Appeal Decision

Appeal Ref: APP/R4408/D/18/3209327
60 Manchester Road, Thurlstone, S36 9QT

- The appeal is made under section 78 of the Town and Country Planning Act 1990 against a refusal to grant planning permission.
 - The appeal is made by Mr David Cooke against the decision of Barnsley Metropolitan Borough Council.
 - The application Ref 2018/0462, dated 20 March 2018, was refused by notice dated 7 June 2018.
 - The development proposed is a house extension.
-

HOUSE EXTENSION 60 MANCHESTER ROAD THURSTONE
 PLAN , ELEVATIONS 1:100 3/2018 DRG A1
 REVISD NORTH
 ELEVATION 5/2018

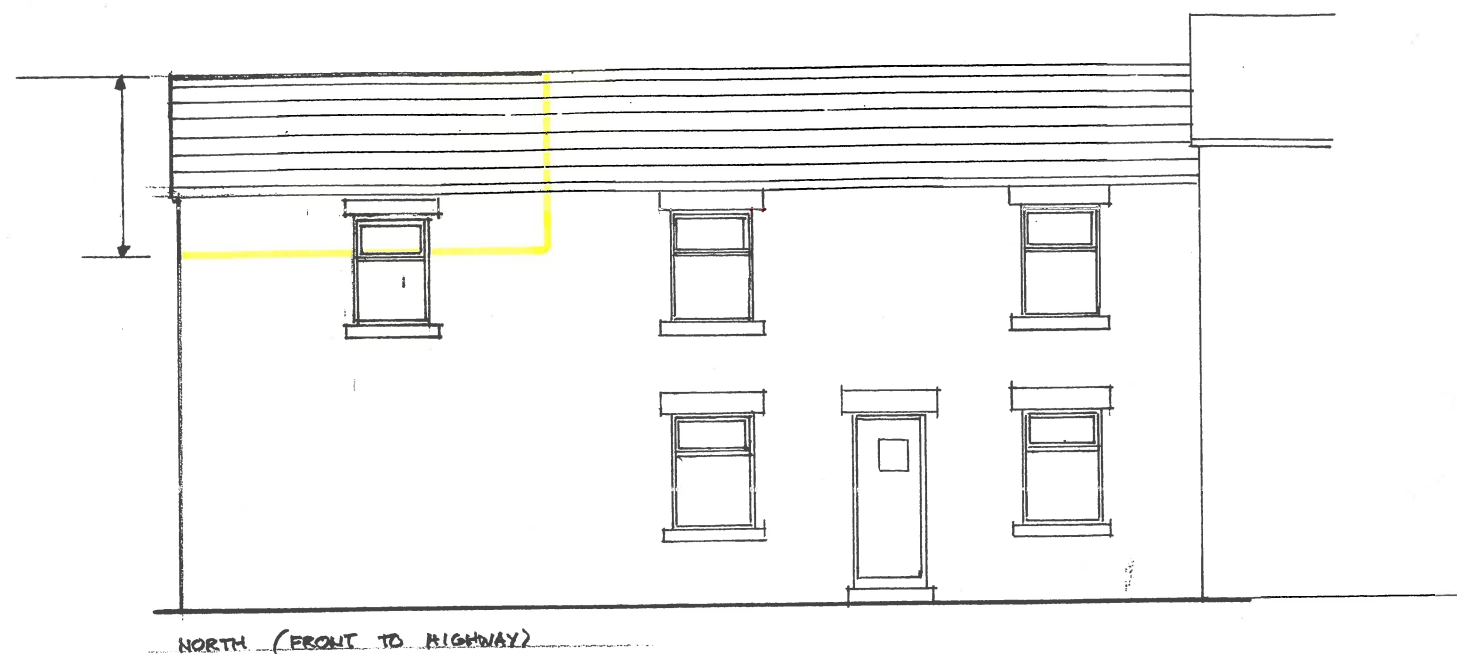
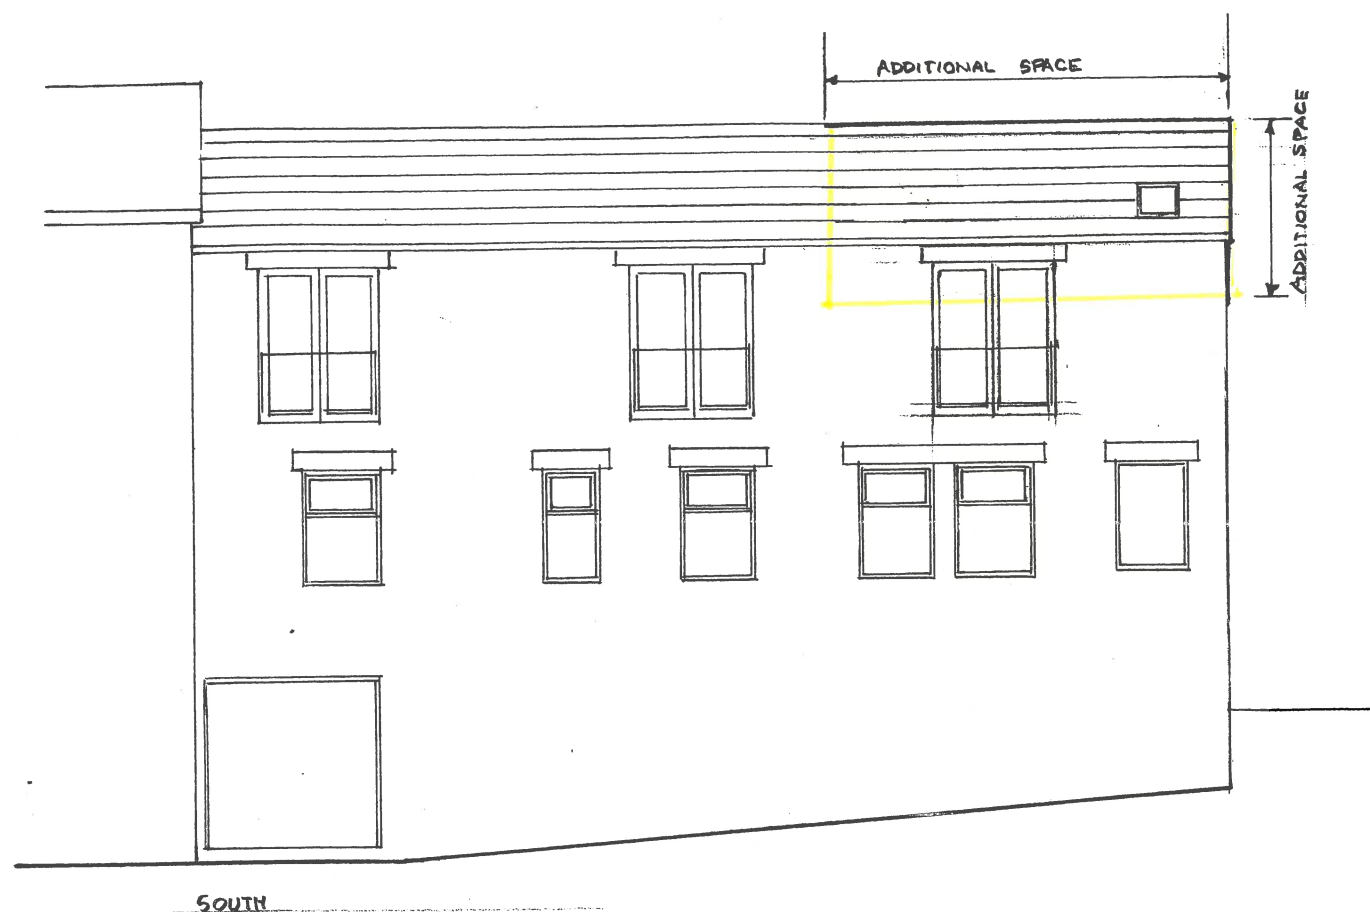
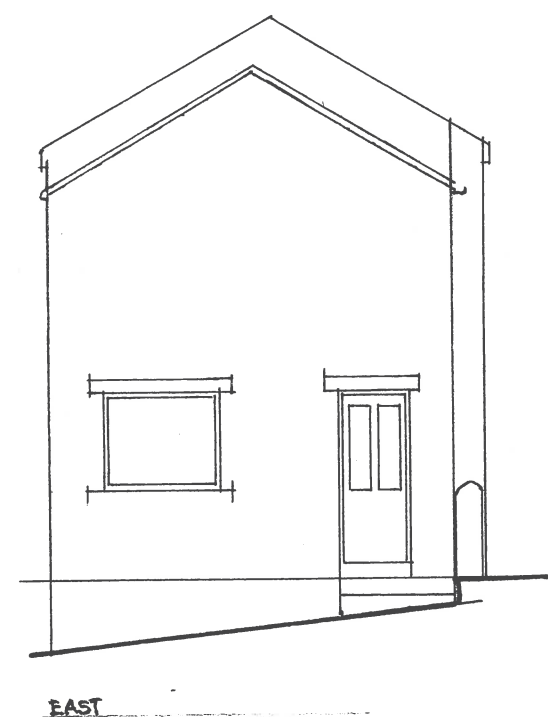
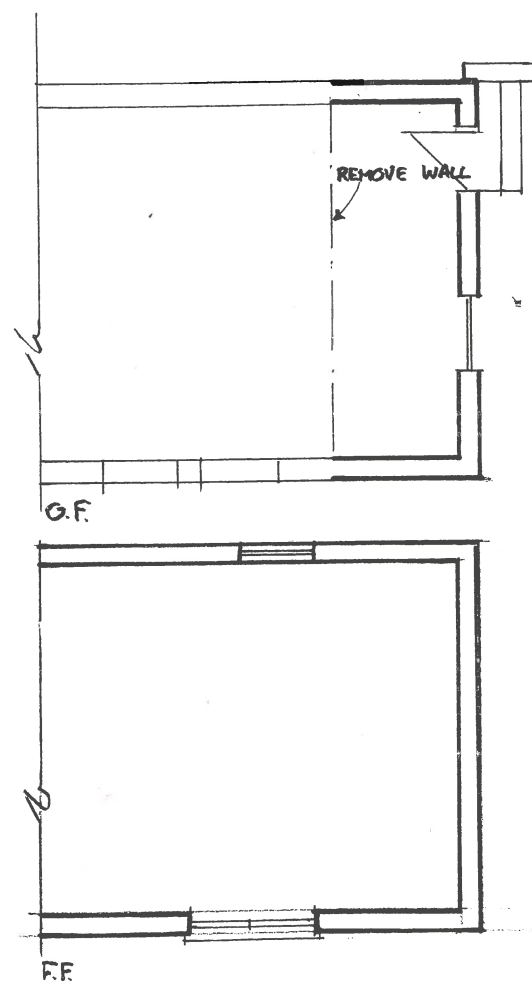
10. The proposed development would result in a first floor extension over the single storey side part of the property, including the recently approved extension. The proposal would not be set back from the existing front elevation and would incorporate a pitched roof that would extend to the existing ridge height, without any set down. A single window, at first storey height, is also proposed.

11. Taking all of the above into account, I find that the proposed development would result in an extension that would appear as a large and unduly bulky addition. The absence of any set back, or set down would lead the proposal to draw attention to itself as a visually intrusive feature. It would result in an addition that would, to some considerable degree, appear so dominant as to subsume the host property, rather than appear in harmony with and subordinate to it.

12. Further, I find that the harm arising from the above would be exacerbated as a result of the proposed fenestration to the front elevation, which would result in a largely blank area of stone work, with just a single first floor window, appearing awkward and isolated within a large expanse of stone-work. This would contrast with the more active domestic frontages of neighbouring properties which make a positive contribution to the Conservation Area's attributes.
